Response to the LPAs Statement of Case

1 SITE PLAN - PROPOSED
Scale: 1:200

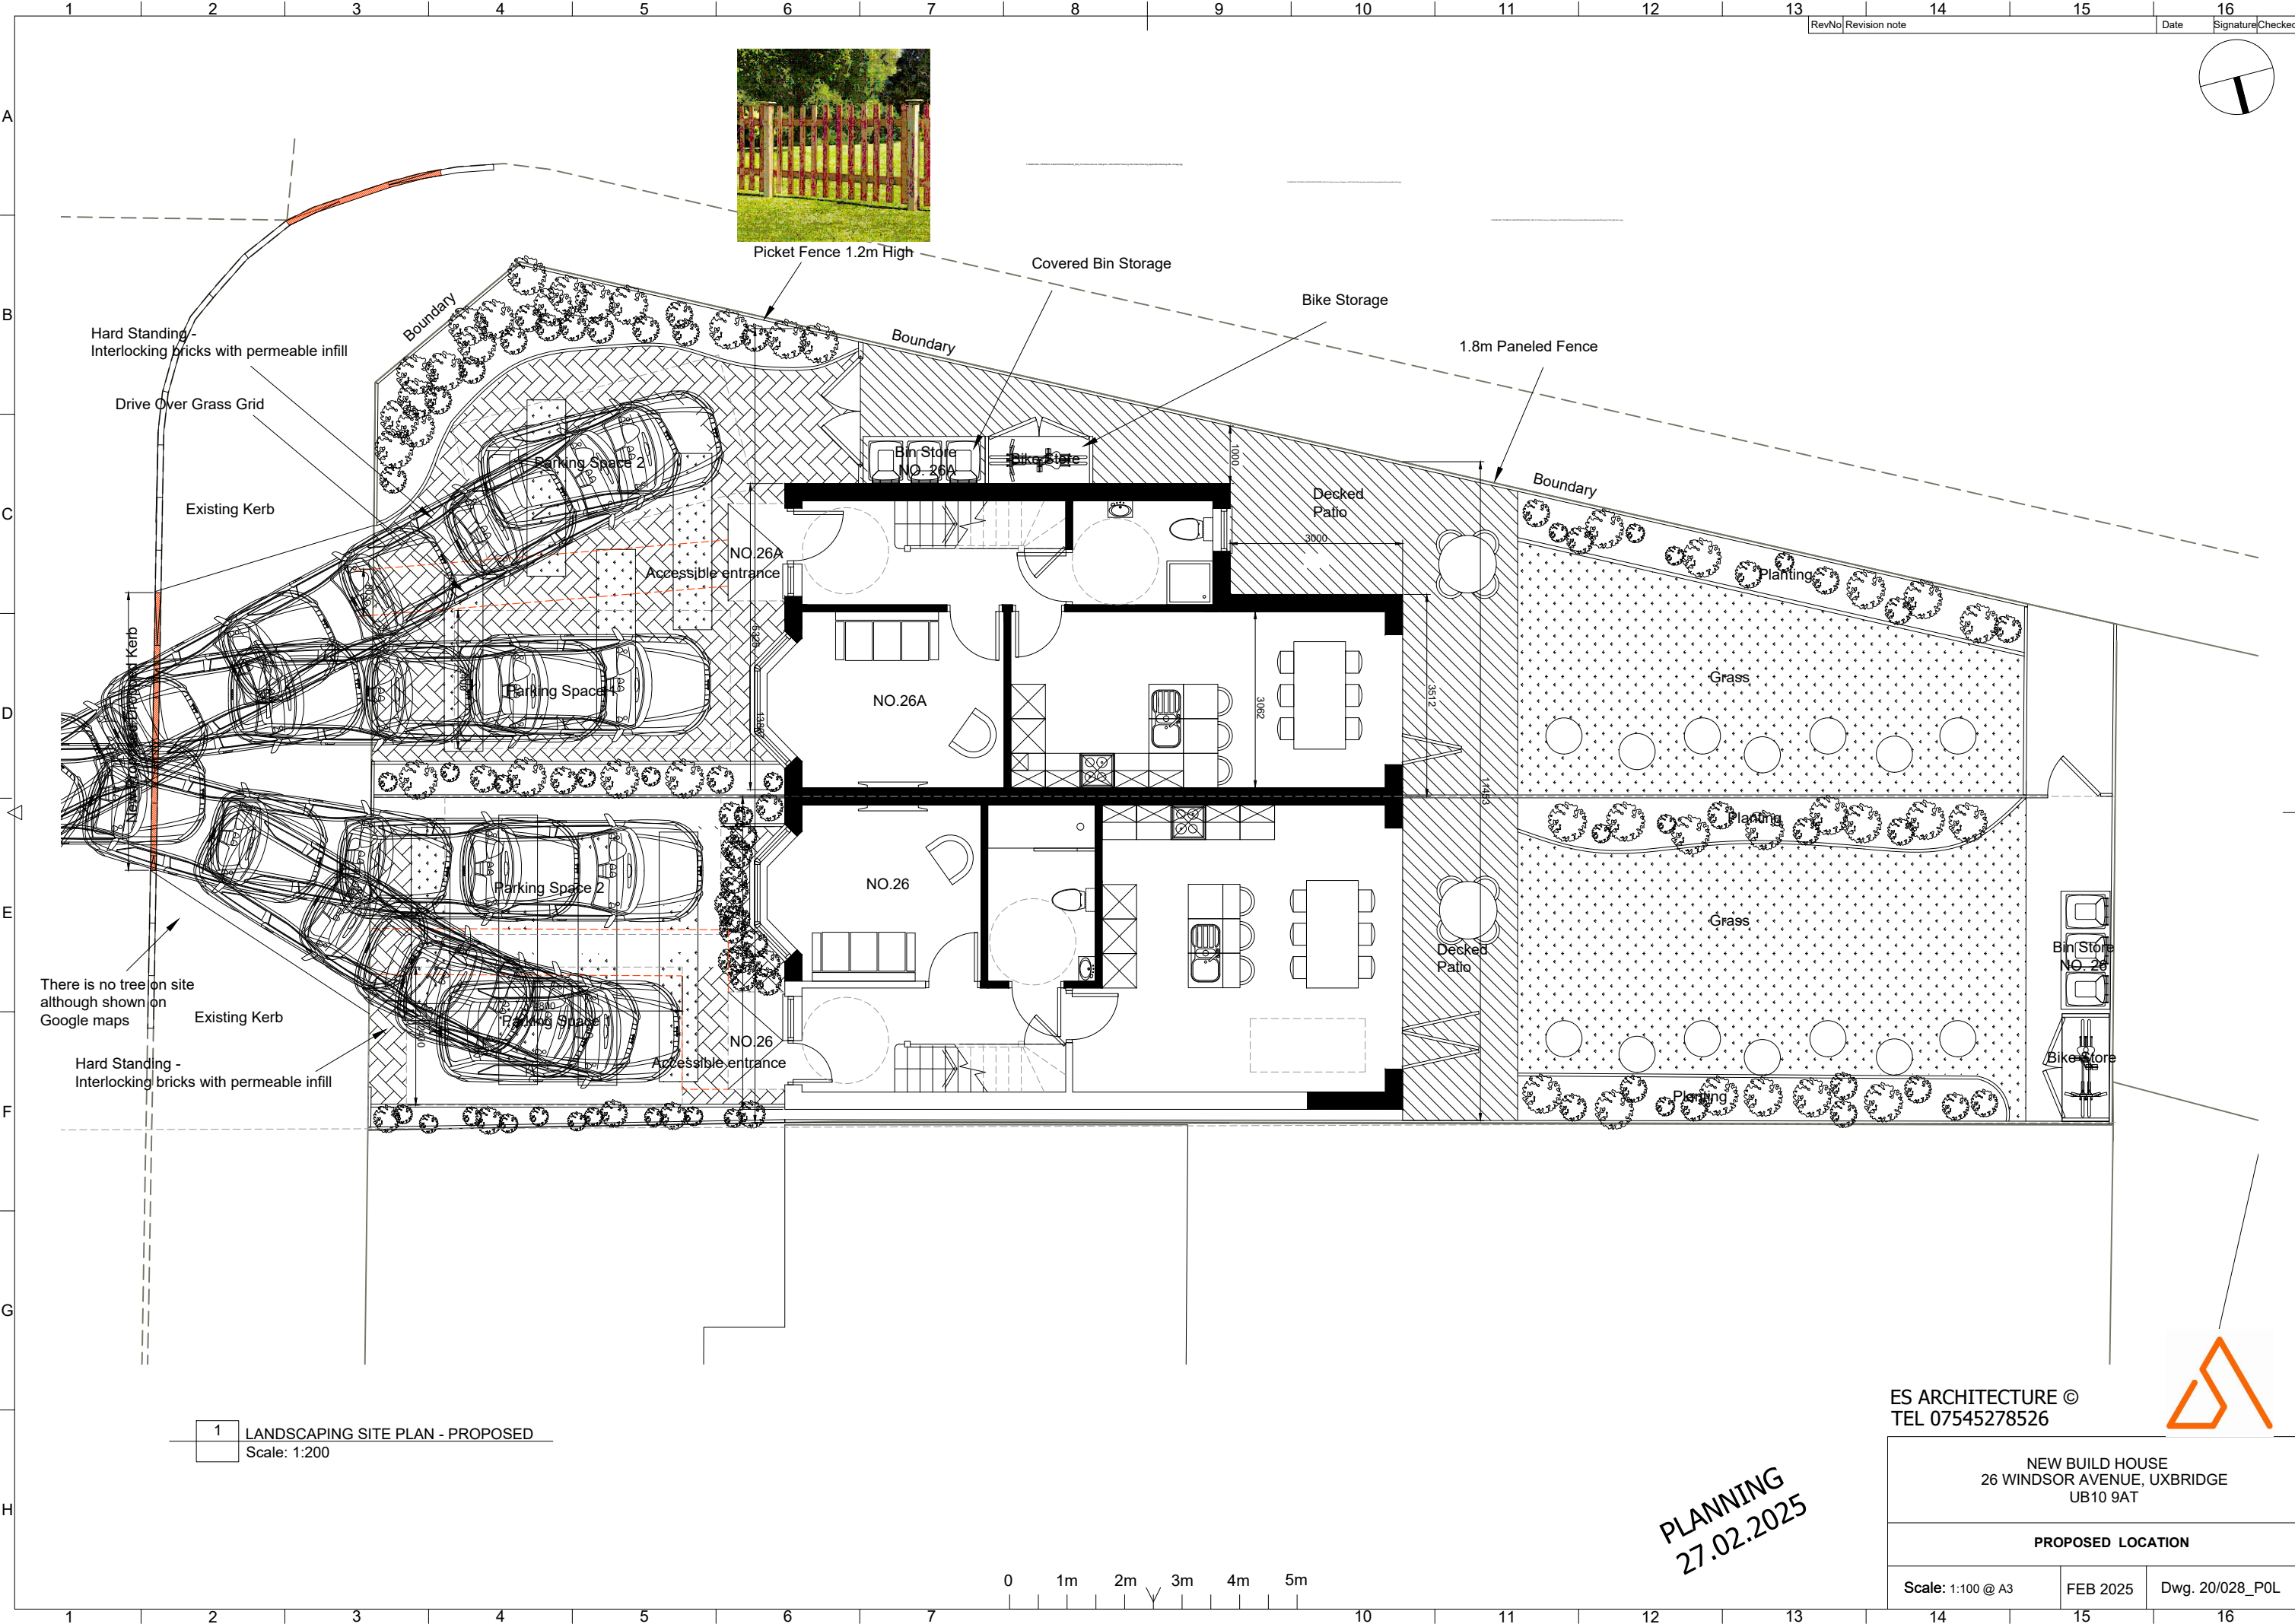
- 2.4 This 'loss of garden land' is seen across the area. Would narrowing the resultant building be an option – no as the LPA would refuse this on a design/appearance perspective. There would be approx. 1-2m separation distance from the common Windsor Avenue highway which is more than enough to retain openness. If the principle of this approach is not acceptable, then the LPA need to say this directly. A balance must be struck as housing is very important and this proposal has been sensitively design and laid out taking into account all material planning considerations.

- 2.14 The appeal decision at no.104 Windsor Avenue is not relevant. This is a clear example of squeezing development of which would have formed a terrace row. The host site and proposal would retain 1-2m from the common highway boundary of Windsor Avenue which is sufficient to ensure adequate openness is retained.

FRONT ELEVATION - PROPOSED

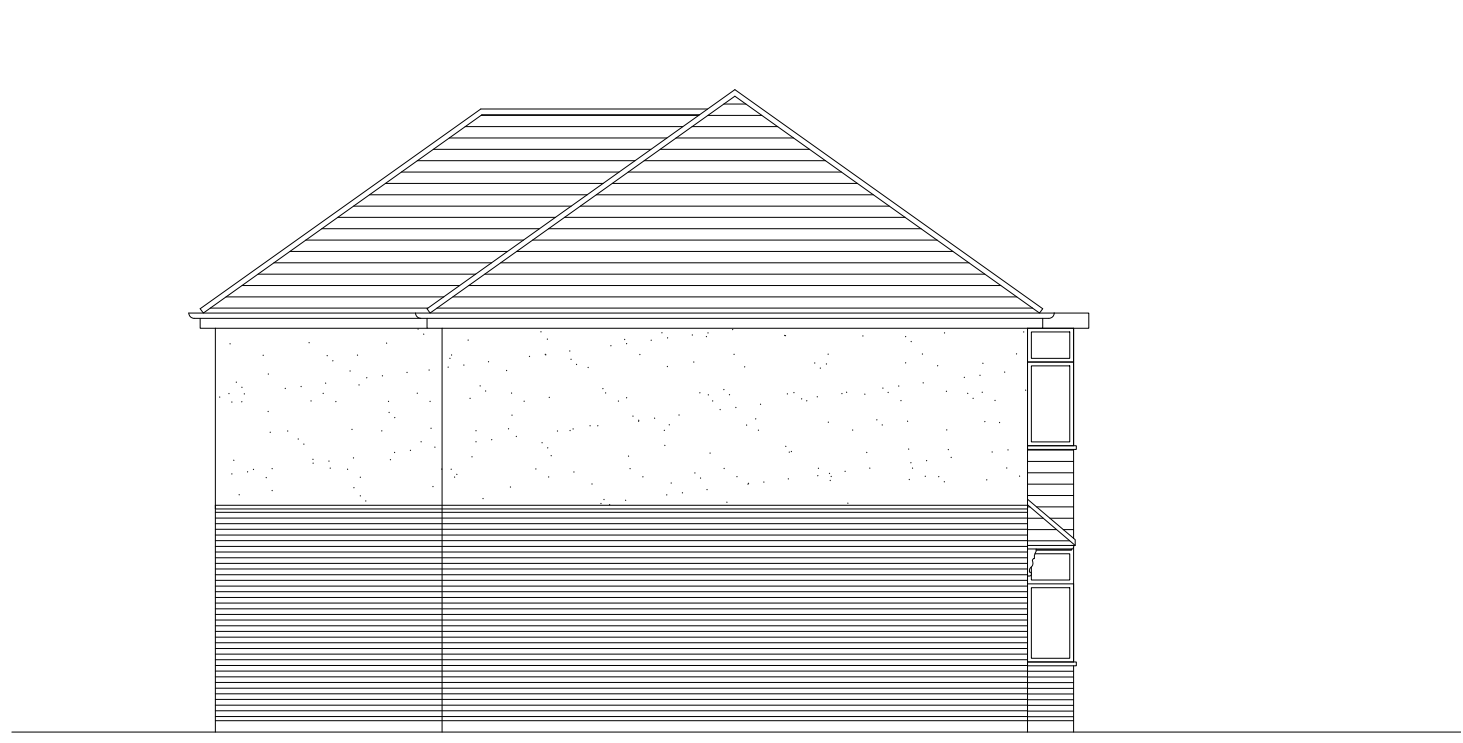
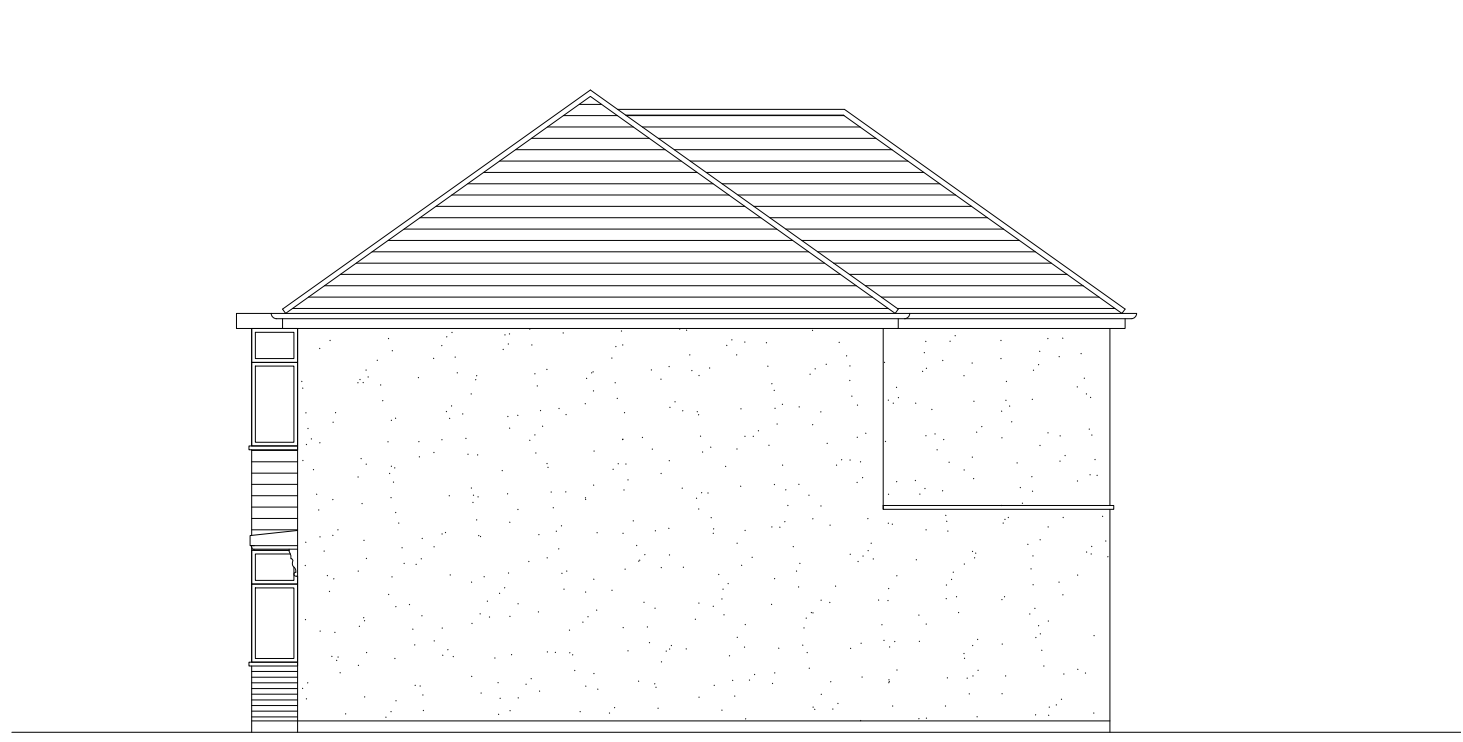
- 2.7 The scale, bulk and mass of the development would in fact reduce by way of lowering the roof. This is not a fundamental change and if the Inspector is minded to approve this application, the appellant would appreciate if the revised plans can be taken into account.

- 2.10 The changes are clearly not substantial. The LPA have not commented on directly (not said if the changes would help/improve the proposal or not). They seek to lower the ridge height to match the neighbouring roof heights and internally alter the walls to allow 'sufficient' GIA to be provided. How these changes would be substantially different is quite baffling.
